Subject: Re: FW: 23260 - The Laurels, Dappers Lane

I recommend discharge of condition 14. Please ensure the following plans are detailed in the approval:

- 103_D_Impermeable Areas
- 201_B_Proposed Drainage Layout and Levels
- 501_B_Construction Details

Condition 14

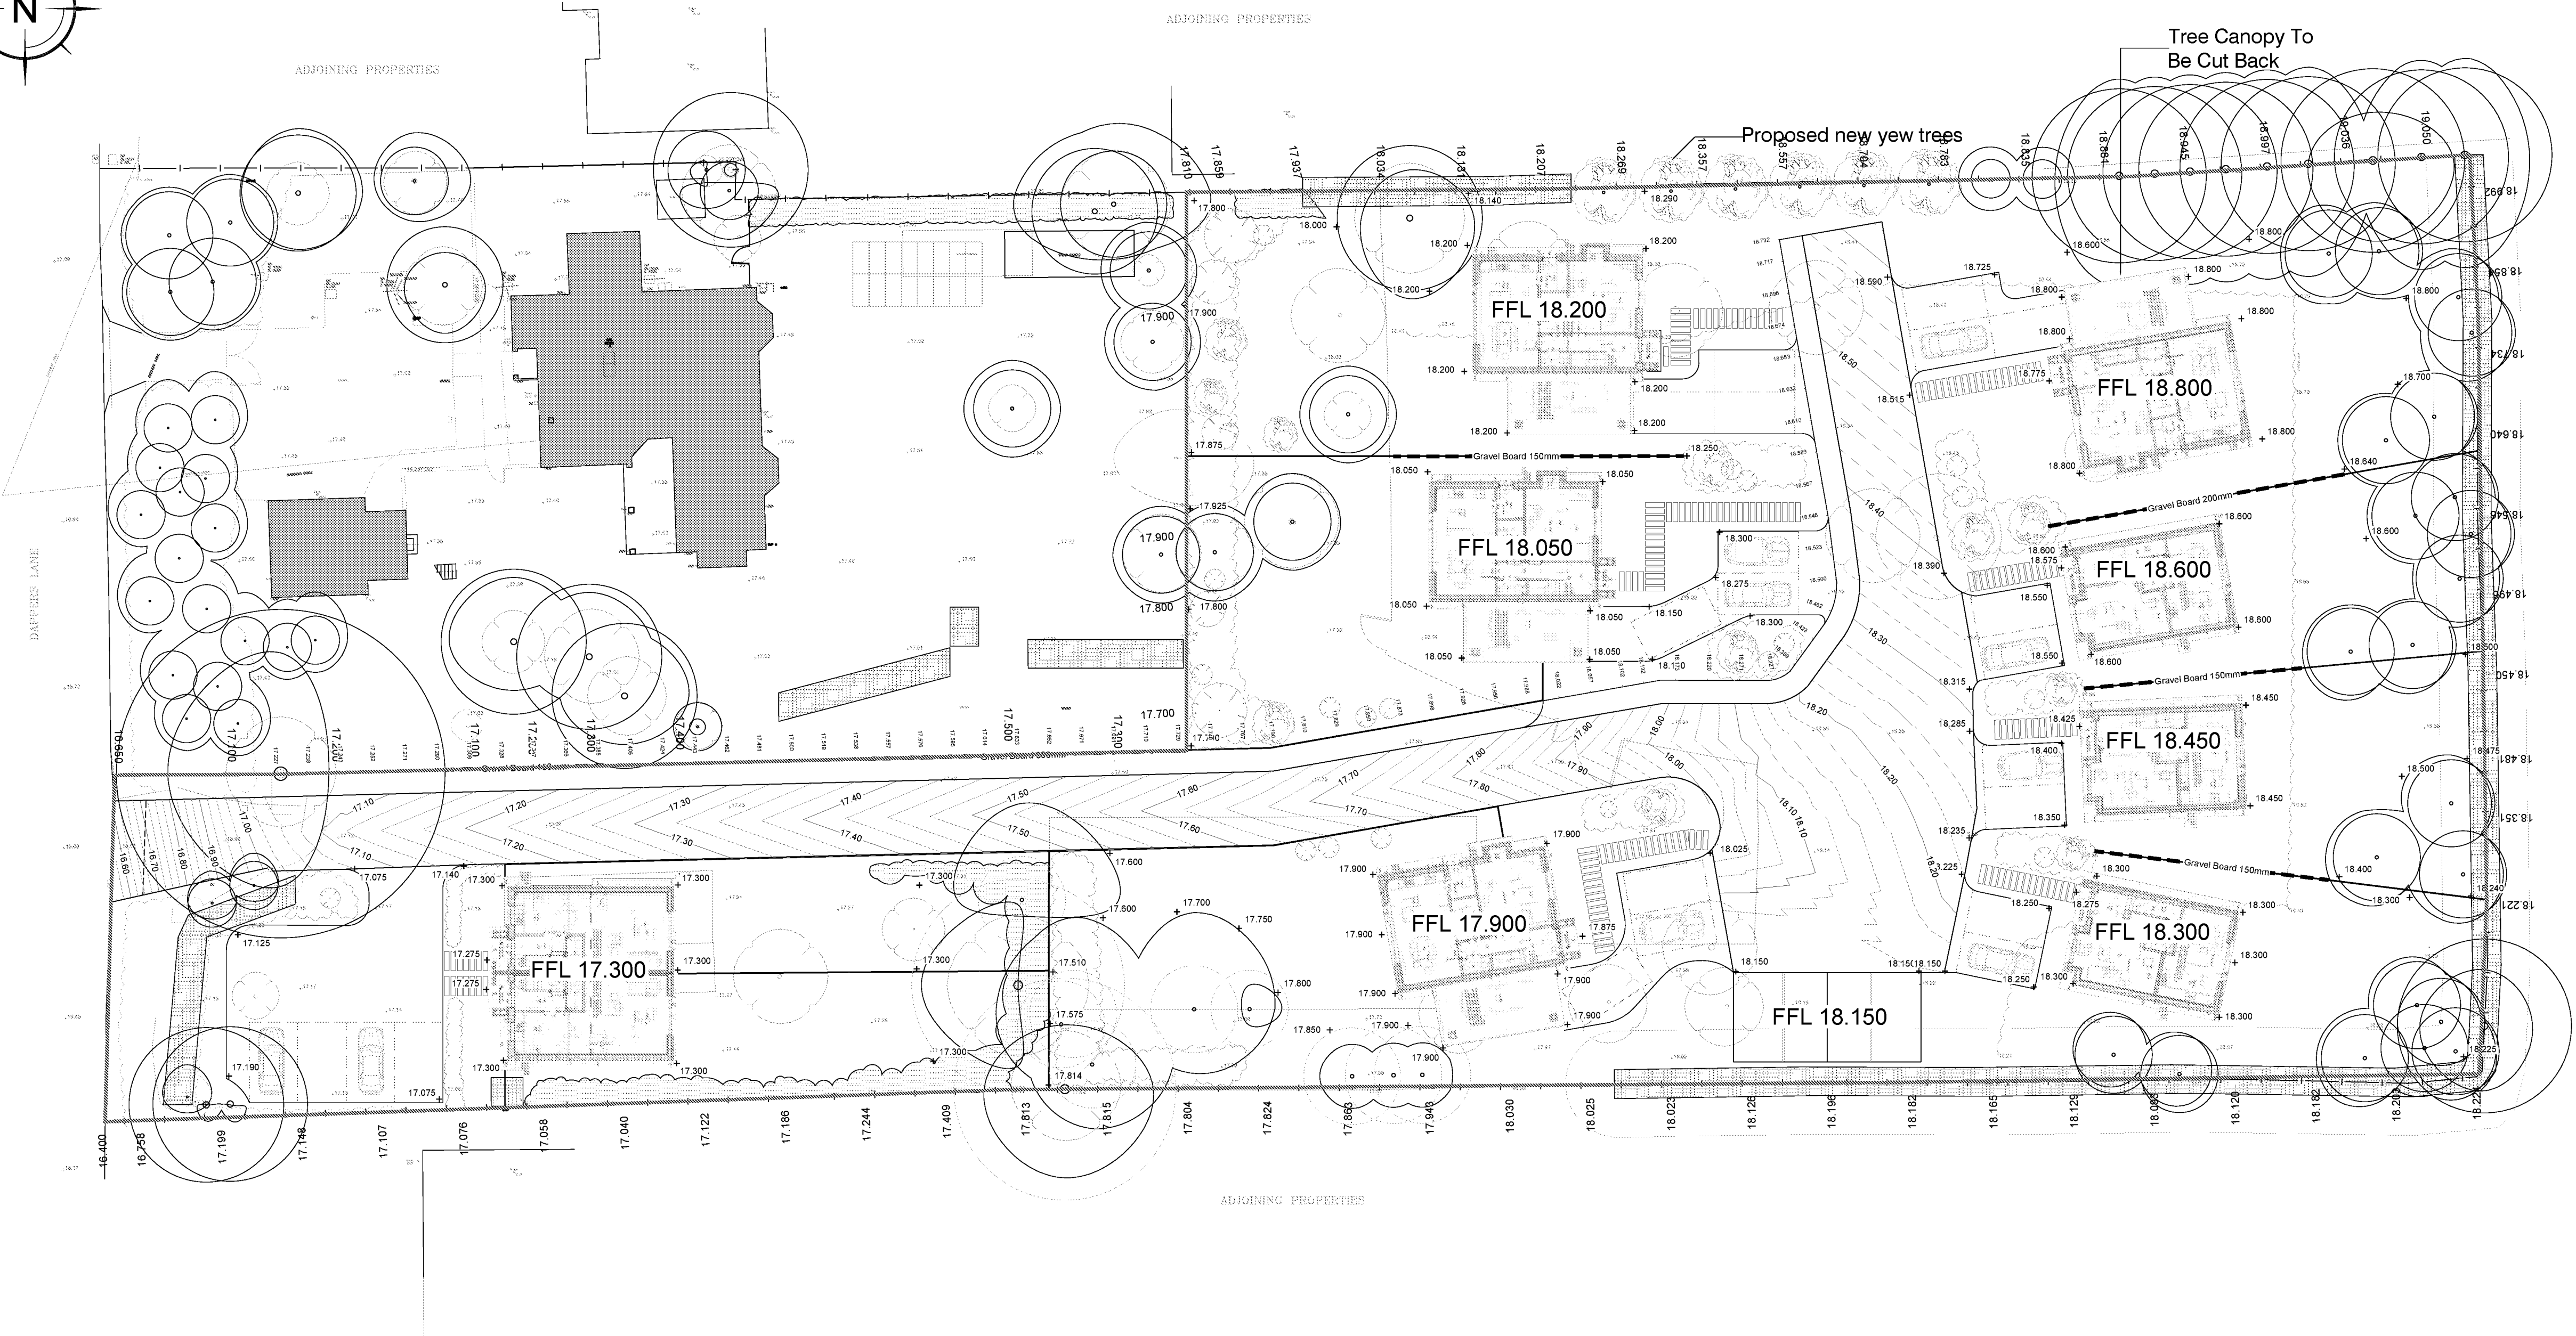
1. We have added this baffle between catchments A and C which is now shown on the revised Drawing 201 attached.
2. The subbase formation level is flat meaning there is no gradient at the base of the highway construction so each catchment acts as an infiltration blanket. The subbase thickness will therefore vary and will be greater than the minimum thickness required for surface water storage in all cases. We have shown these formation levels on Drawings 103 and 201 attached. Drawing 501 has also been updated including a note stating that the subbase thickness varies.
3. This detail has been added to the construction detail on Drawing 501.
